**Consultation Response from KC,
Lead Local Flood Authority**

2025/93500 adj, 208, Yew Tree Road, Birchencliffe, Huddersfield, HD2 2EQ

Discharge of details reserved by conditions 6 (Phase II Intrusive Site Investigation Report), 7 (Remediation Strategy), 14 (Temporary drainage), 16 (drainage strategy, 17 (drainage attenuation), 23 (construction traffic), 26 (EVC) on previous permission 2018/90151 for outline application for erection of residential development

Date Responded: 16th January 2026

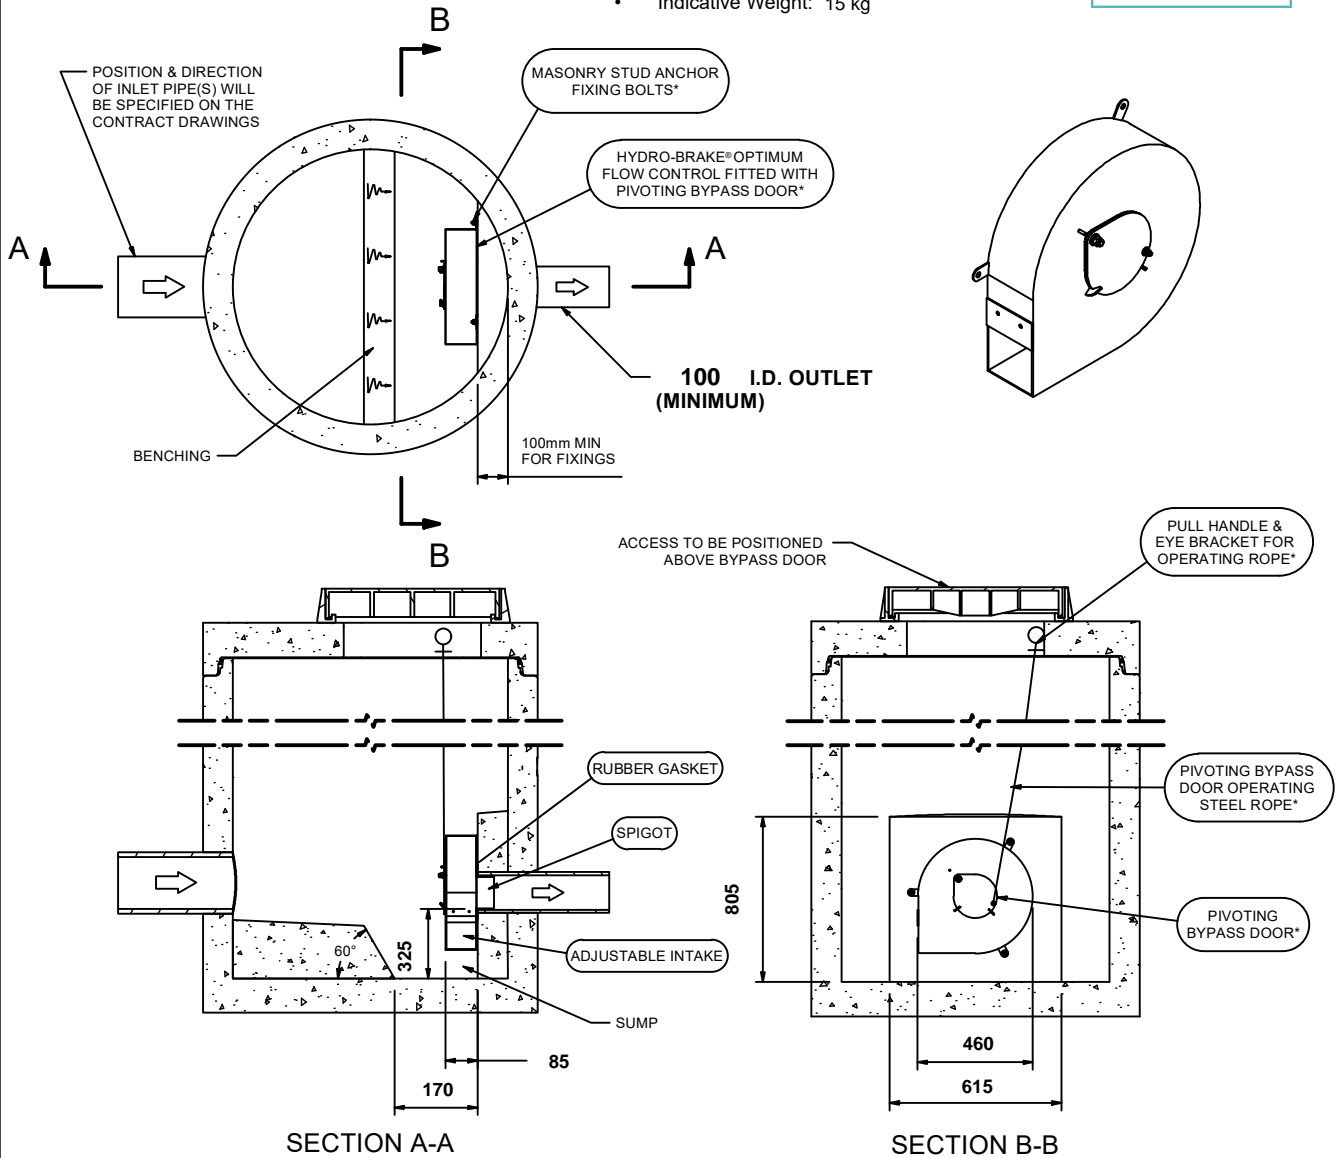
A flow control head flow ratio graph should be provided.

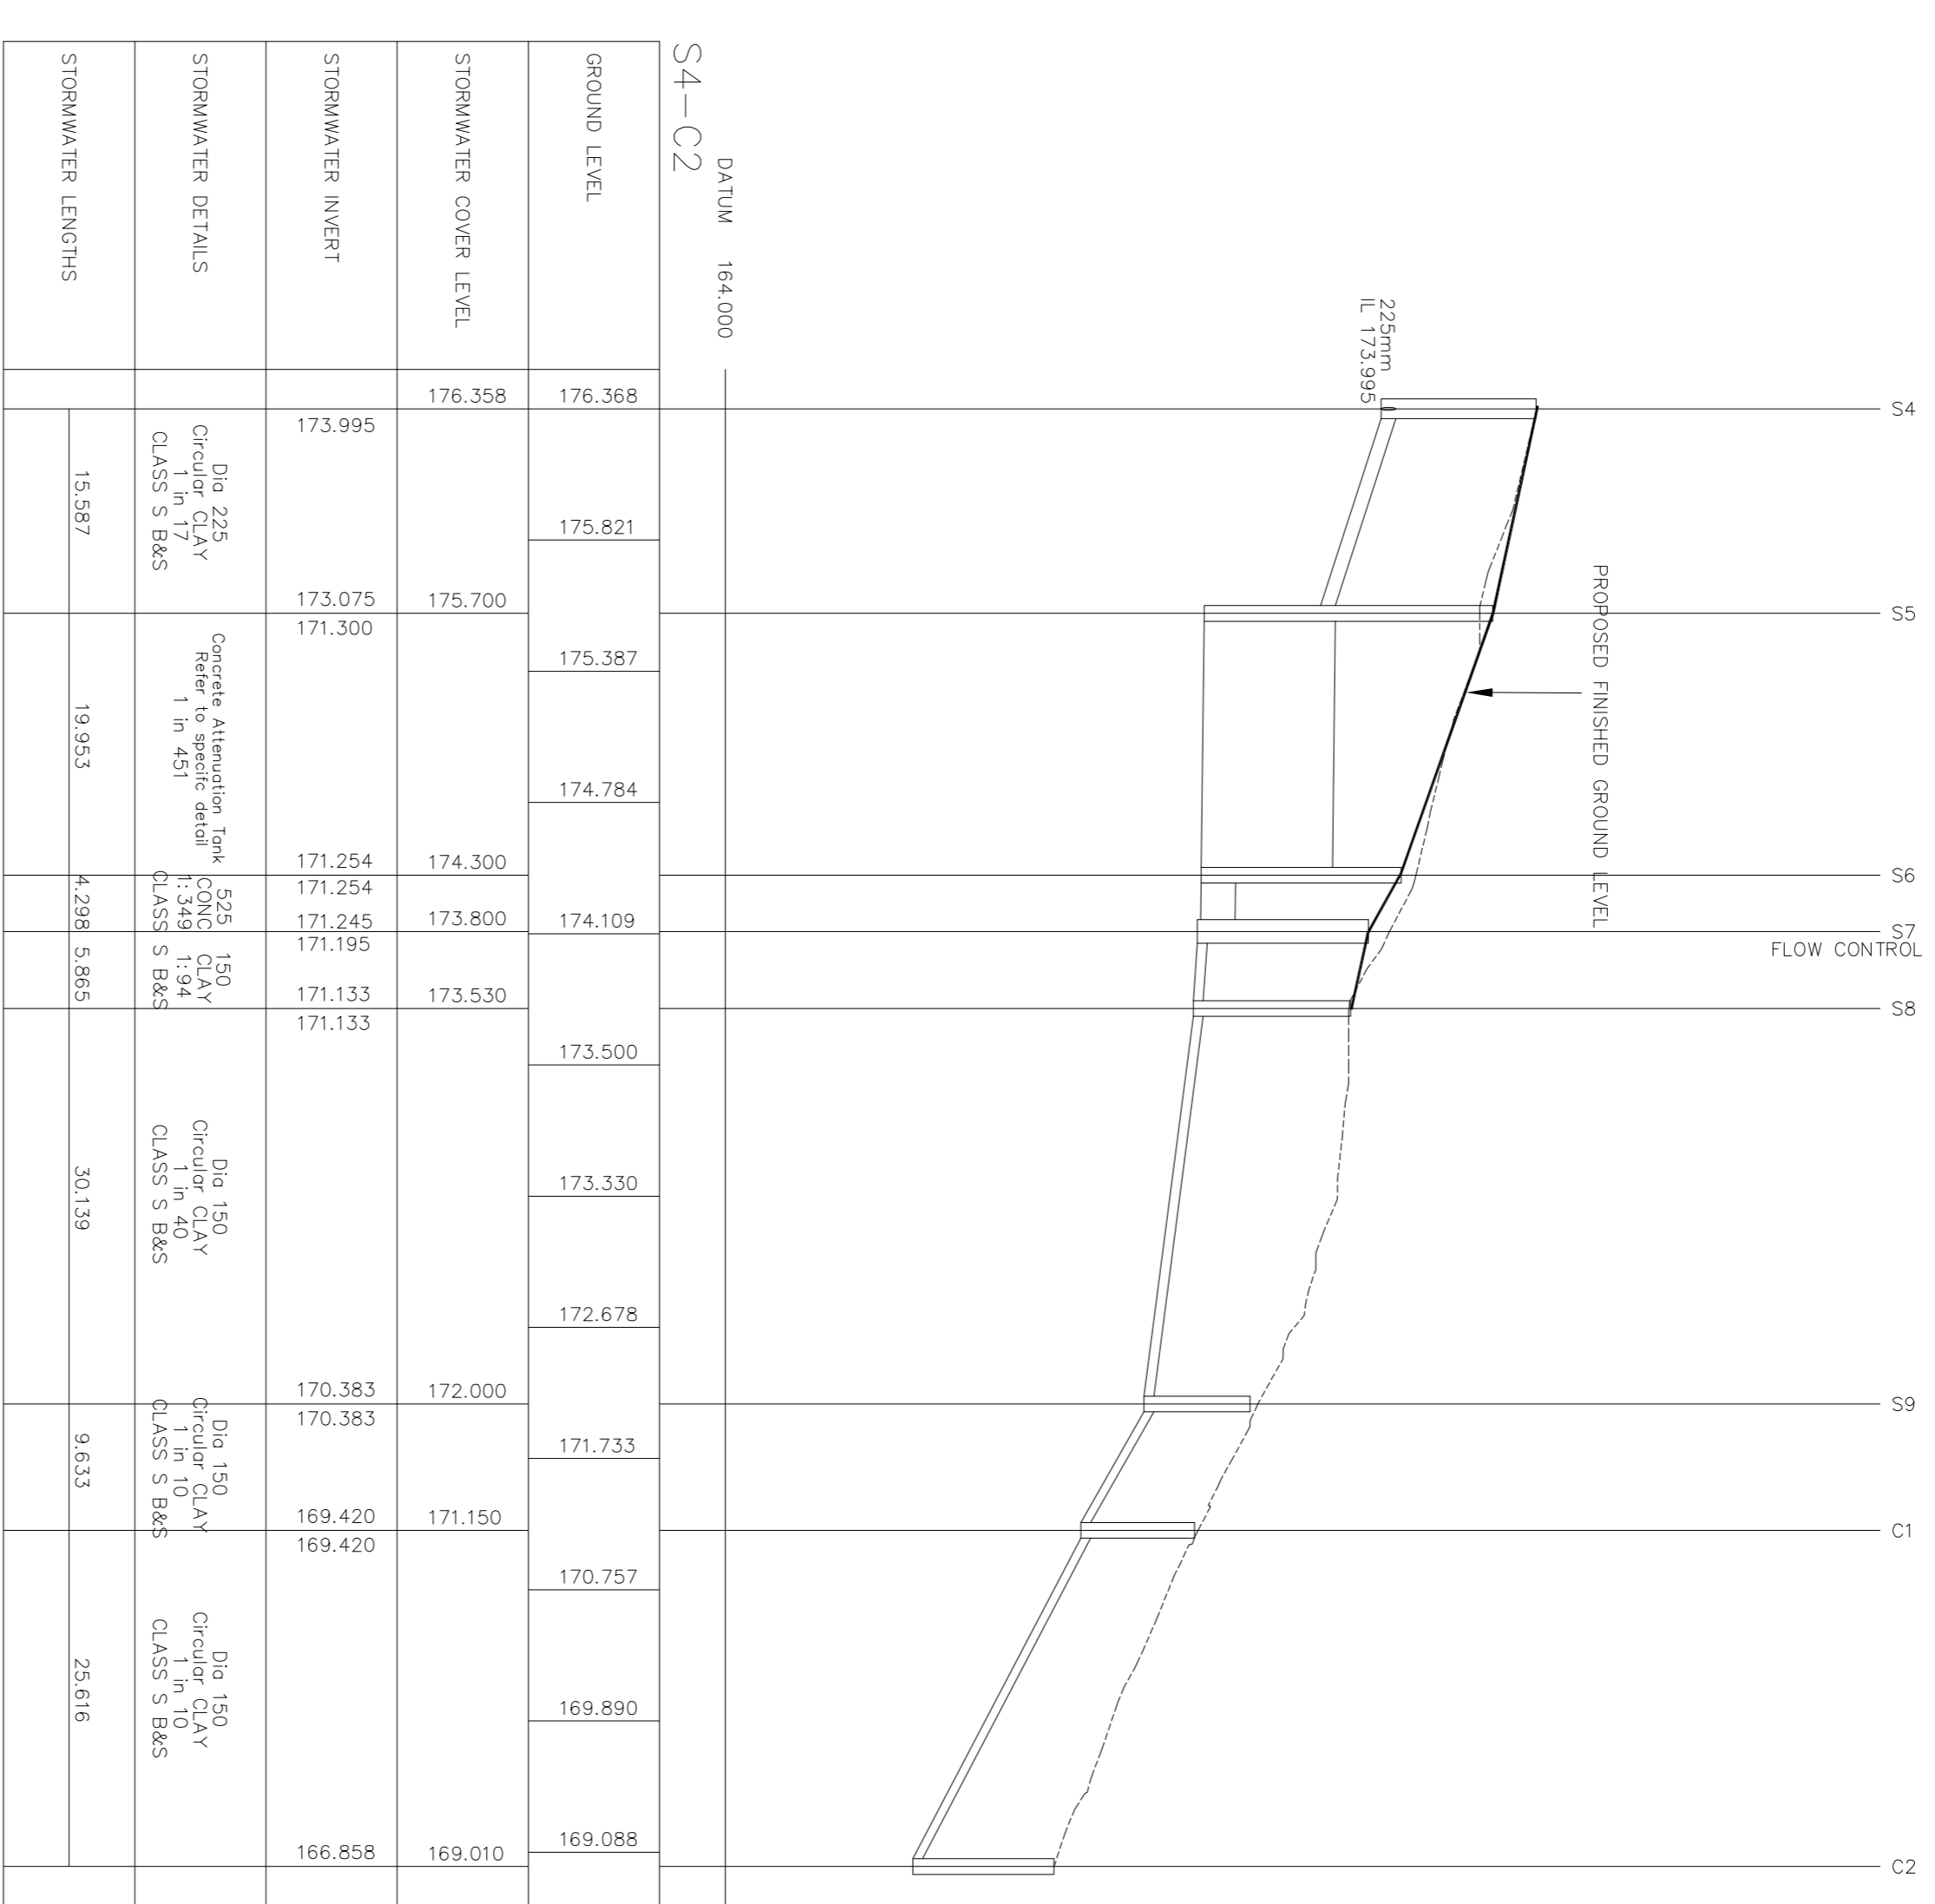
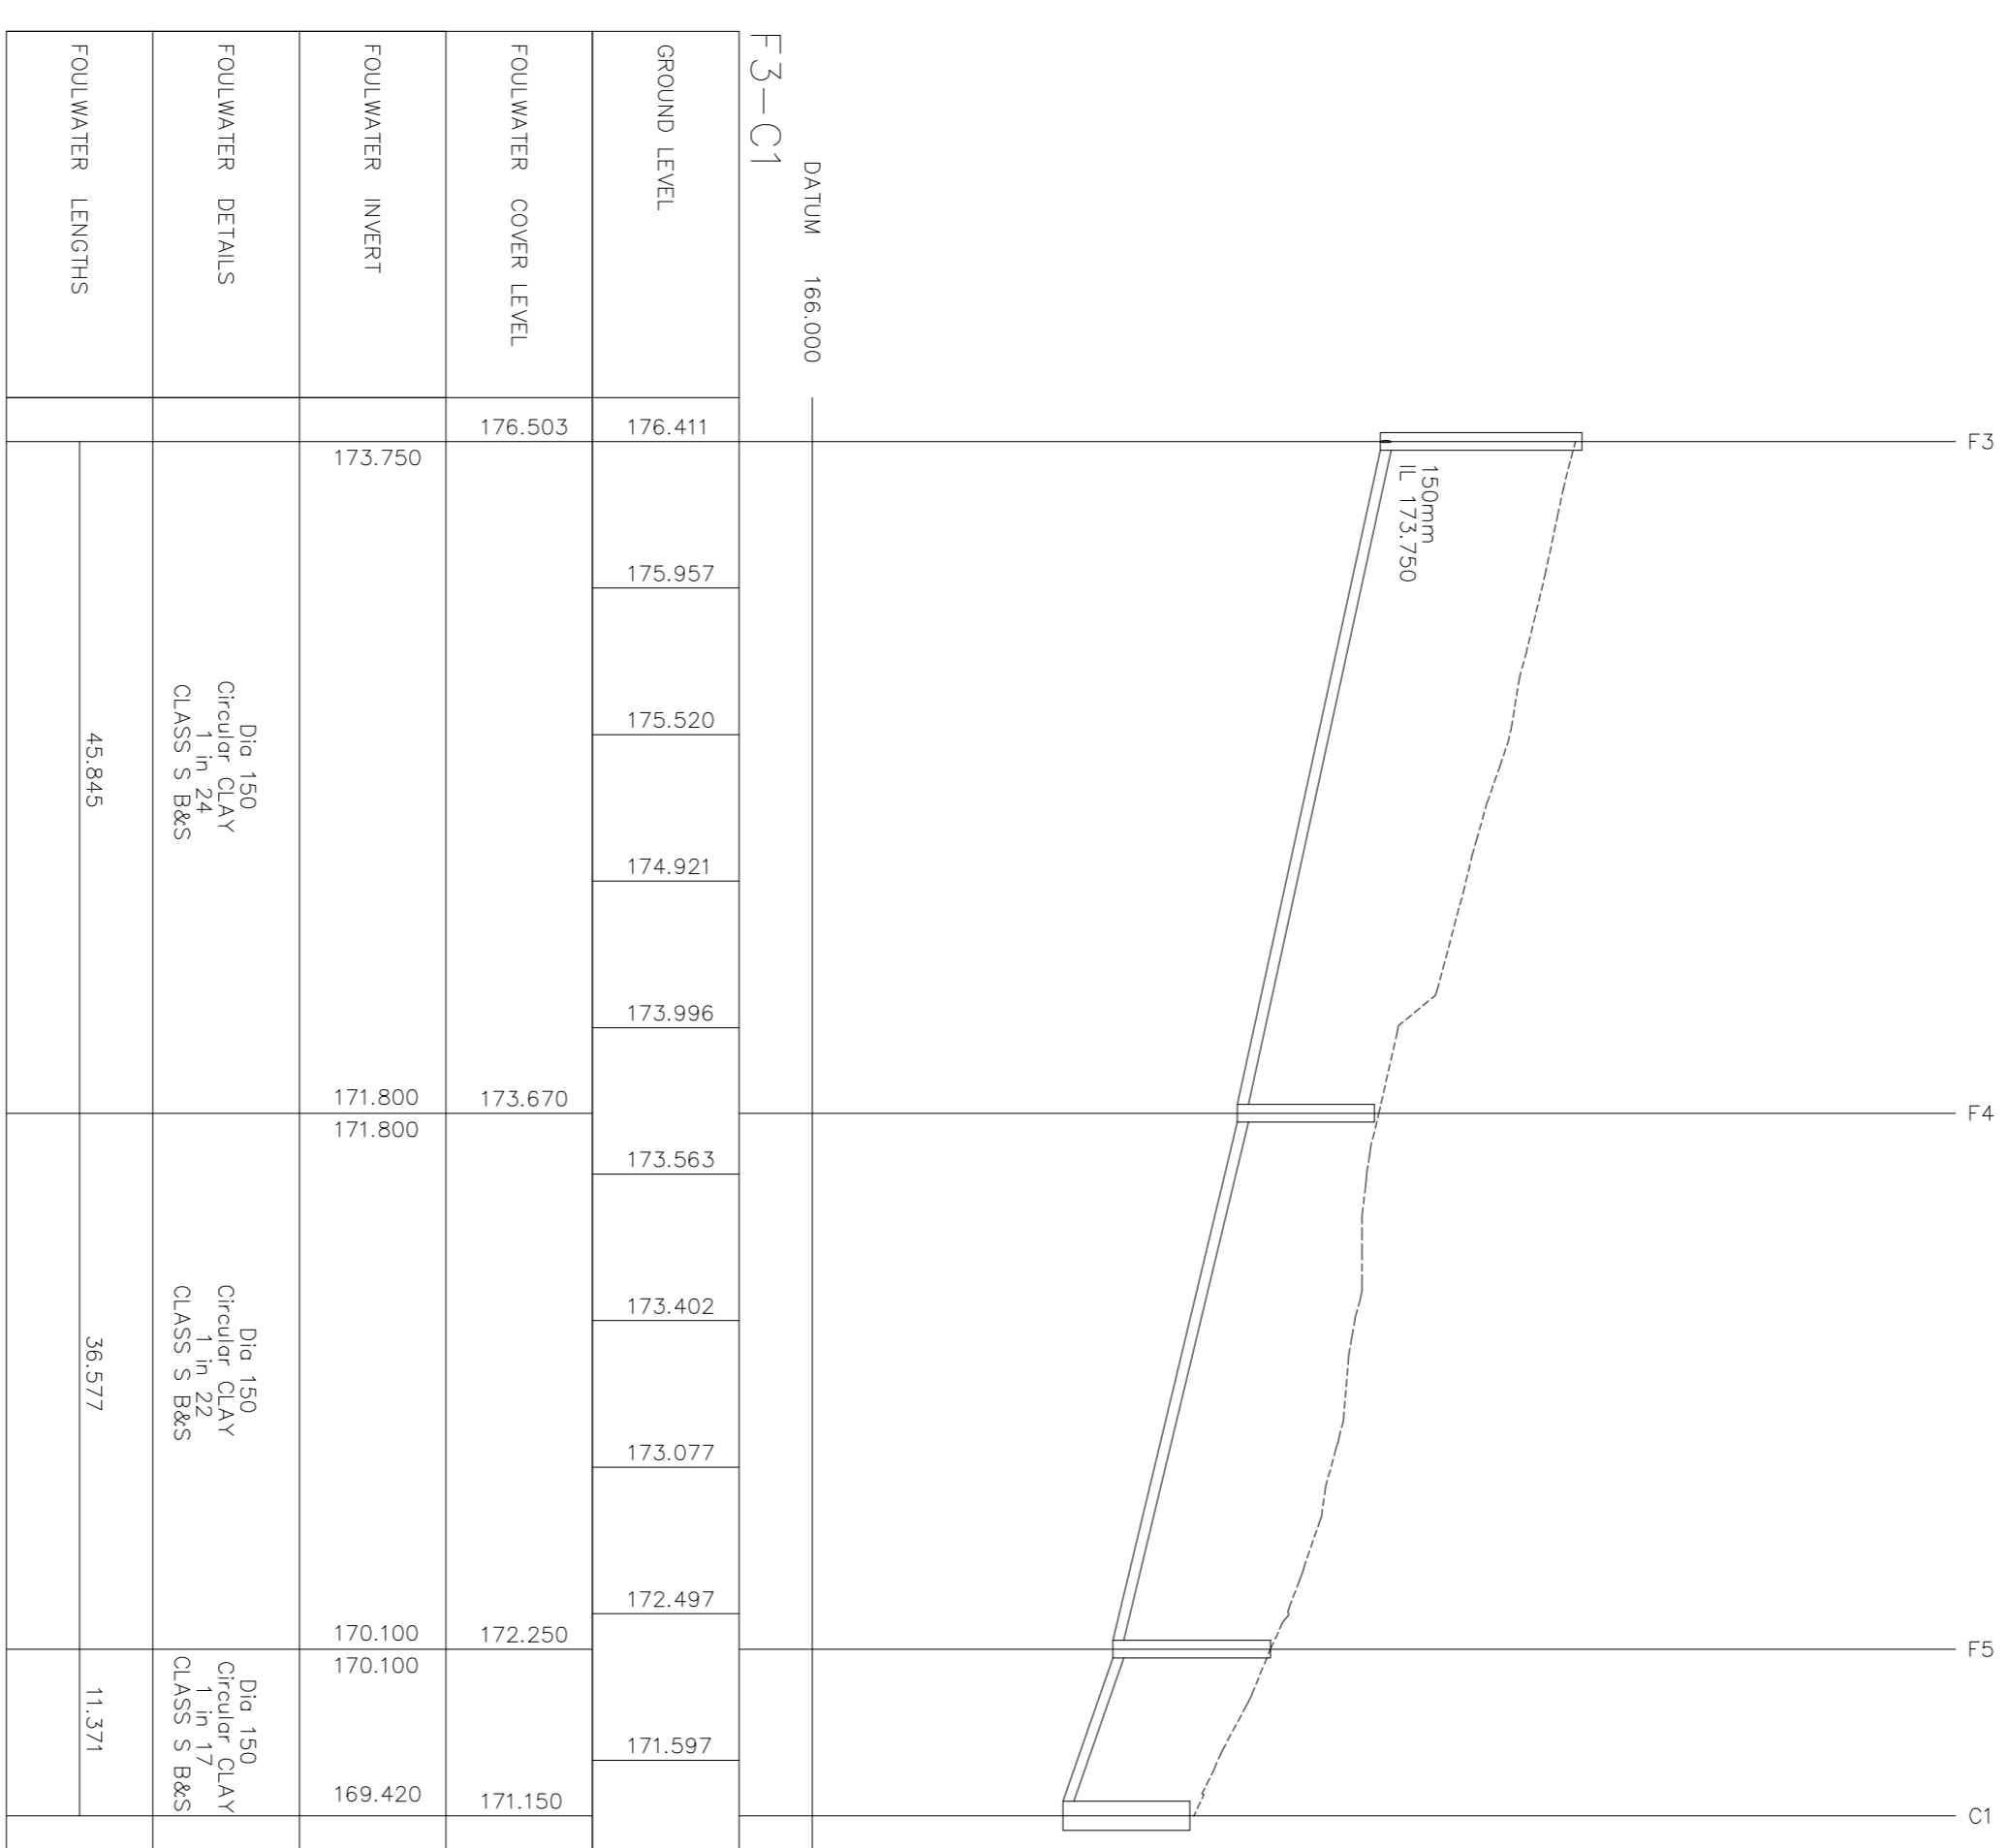
A full hydraulic drainage simulation is required to demonstrate no flooding in a 1 in 1, 1 in 30 and 1 in 100 + climate change event. Details should accurately correspond to a coloured hard standing drawing identifying the areas that contribute to each sewer leg.

Details of safe flood routing is required. Whilst engineering layouts have been submitted, these don't include the private drive adjacent to plots 6, 7, and 8. It appears that water will flow toward these properties and measure should be included to ensure a safe route continues to the main road away from the building.
